I am writing to express my concerns regarding the proposed erection of a community sports complex in our neighborhood. While I understand the importance of having sports facilities in our community, I strongly believe that this proposal should not go ahead for several reasons.

SITE PLAN
 1 : 500

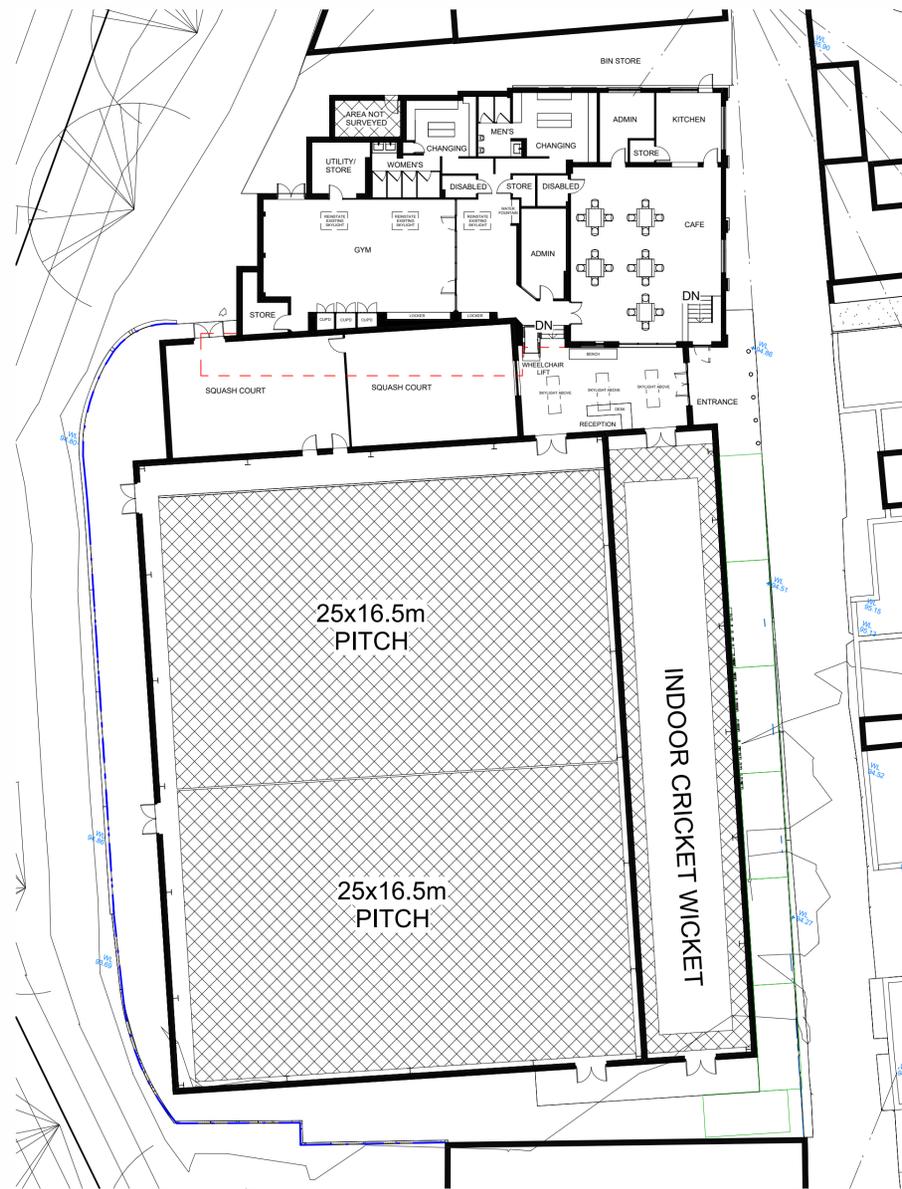
Firstly, the proposed development only includes seven parking spaces, which is a great underestimate of the scale of the development being proposed. The road is very narrow and can only accommodate one-way traffic. Parking is already an issue in the area, and this proposal will only make things worse. Cars are often parked around the rear of properties and on several occasions have been unable to exit due to parked cars obstructing access. Residents struggle to find parking spaces, especially during busy periods such as Friday prayers at the mosque located nearby, often vehicles are left parked in the middle of the road in question. This proposed development will only exacerbate the parking problem, leading to potential safety issues.
